Consultation response from KC PROW (footpaths)

2024/92167 Land off Edgerton Road, Edgerton HD3 3AA

Variation of condition 1 (plans) of previous reserved matters approval 2017/90190 pursuant to outline permission 2014/93014 for erection of residential development comprising of 41 dwellings plus associated works (within a Conservation Area)

Date Responded : 18/10/24

Deveron Grove
Proposed Site Layout

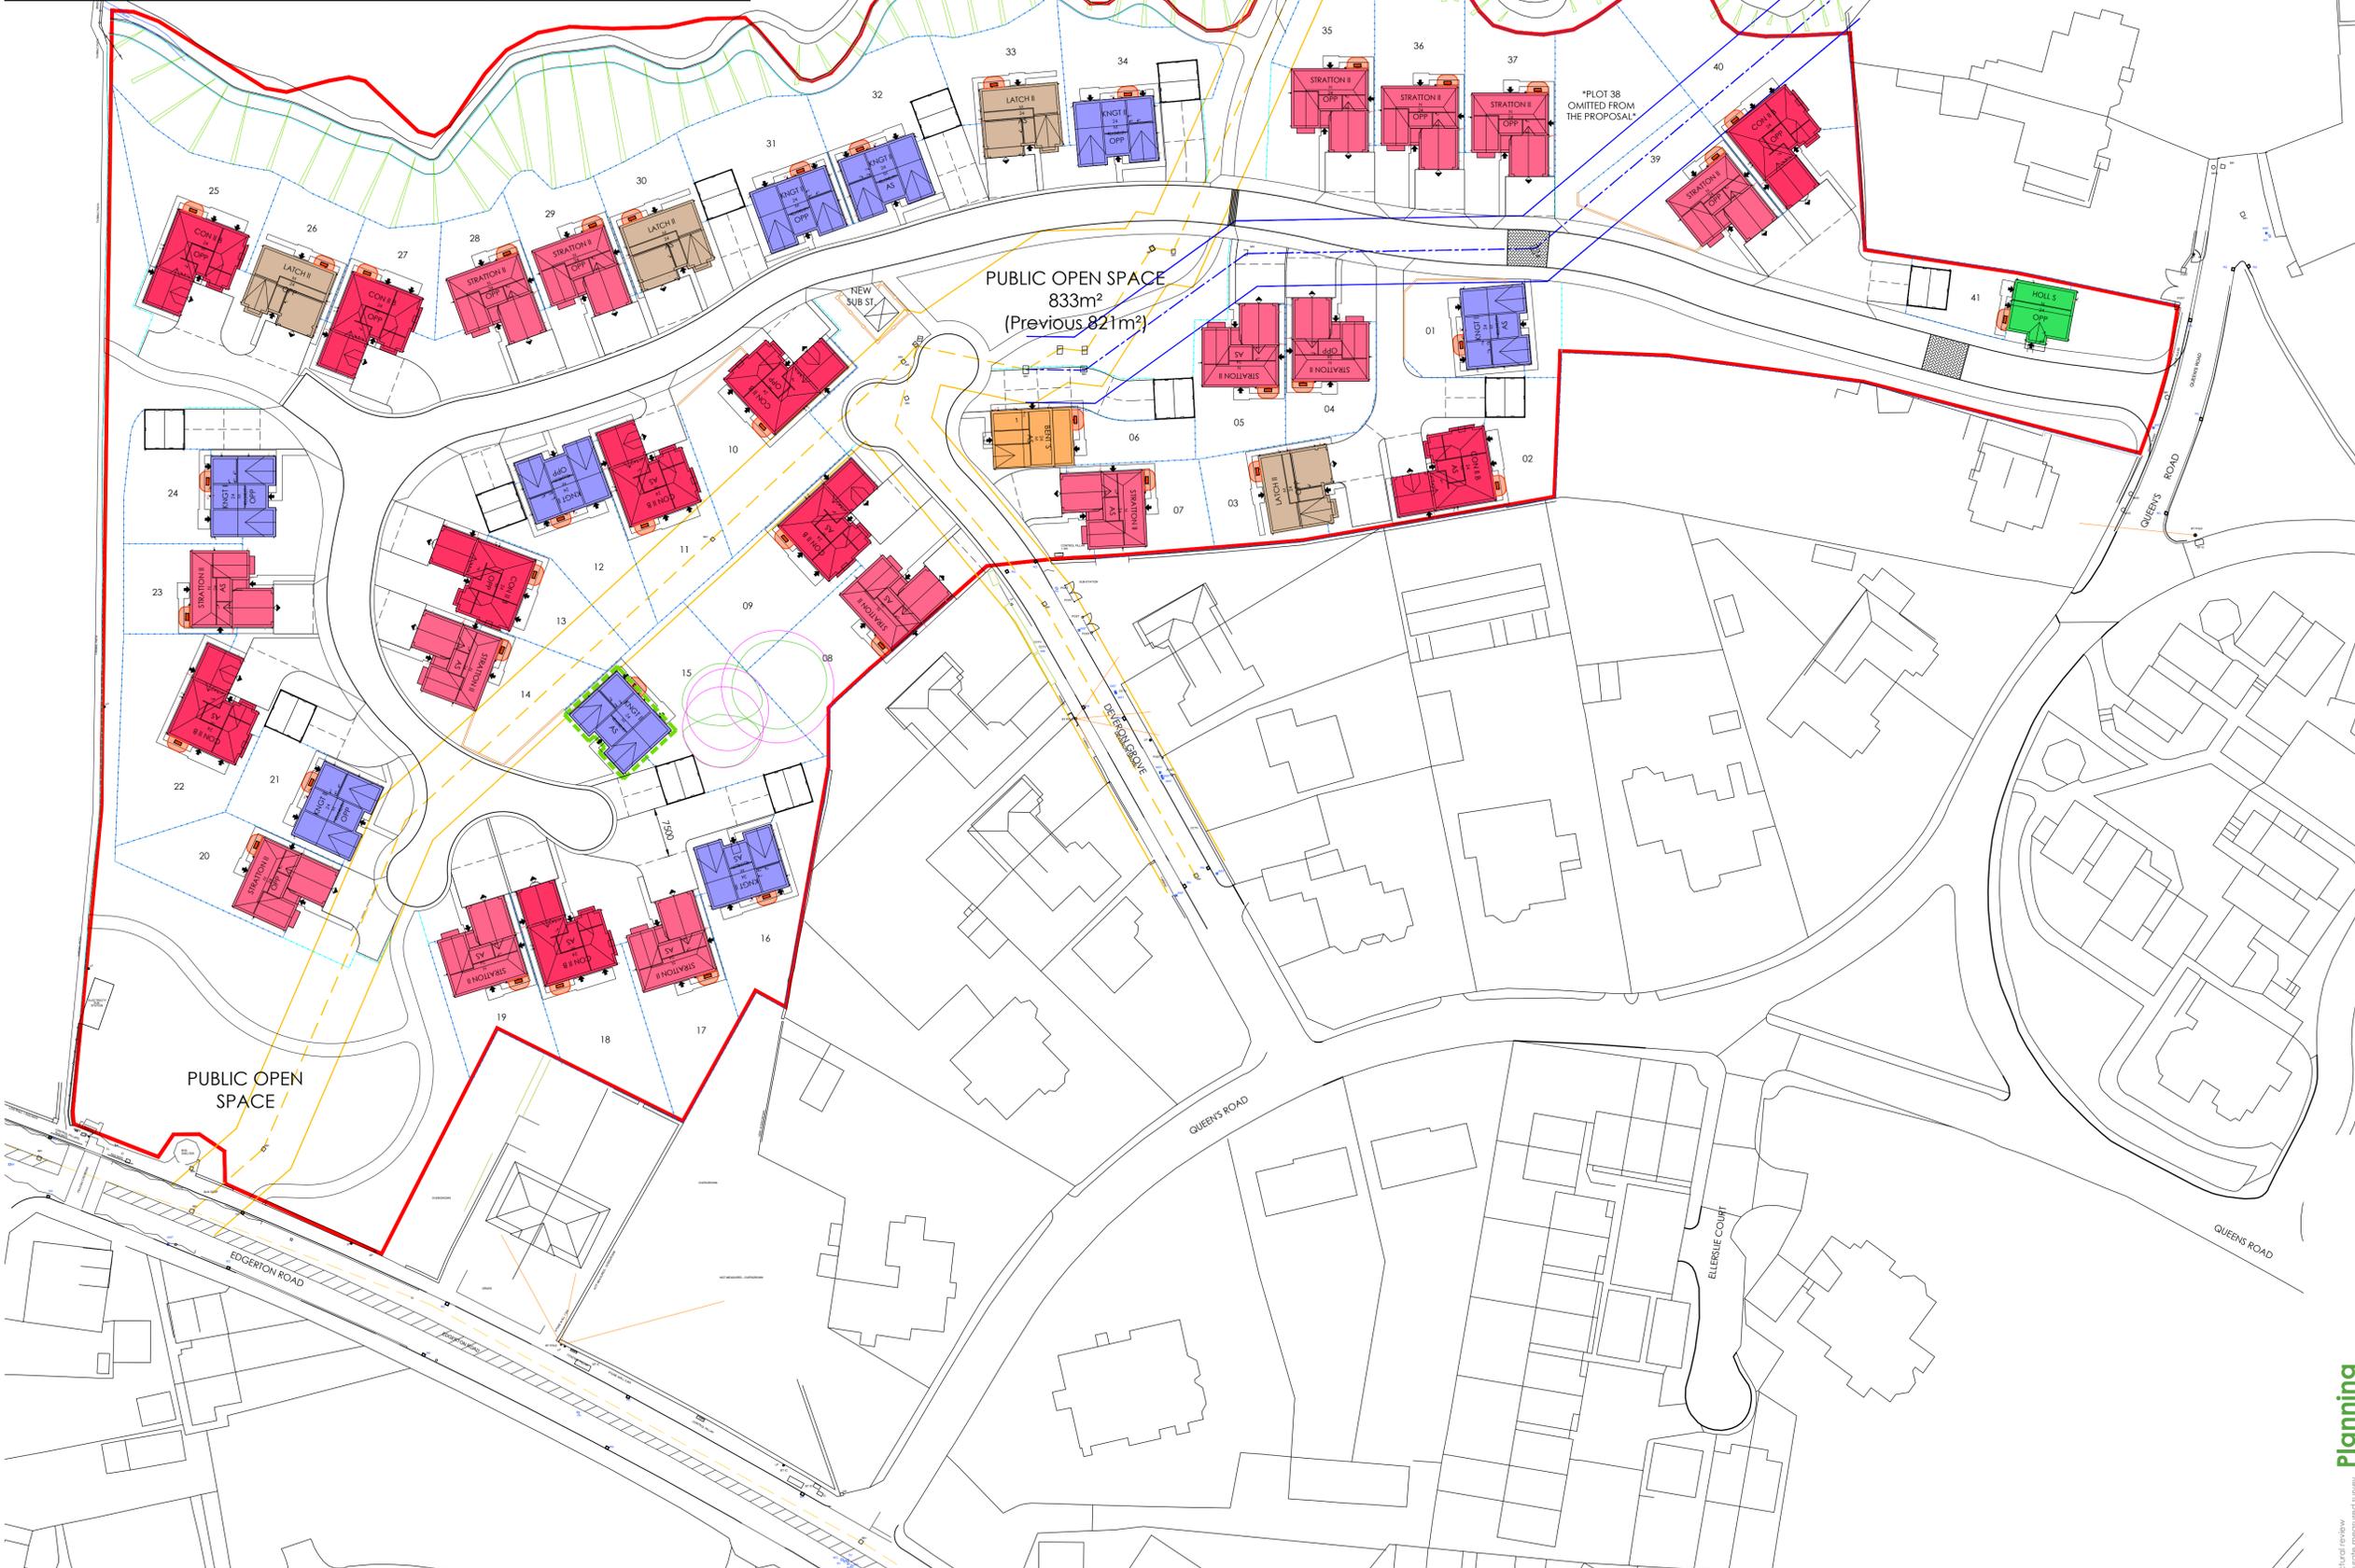
Further to a conversation with the planner and the discussion of the path through the POS, prow has measured these and they are showing as 2 metres.

The provision of alternative routes from the extinguishment and provision of new routes order appears to match.

Prow has checked the alignment of the current proposal (the same as in Anite 13/3/24 2489-1-001) with the previous permission and the order plan prow are satisfied that the route are a close match, except for the access where it meets Queens Road. However, this when built will be part of the Highway maintainable at public expense.
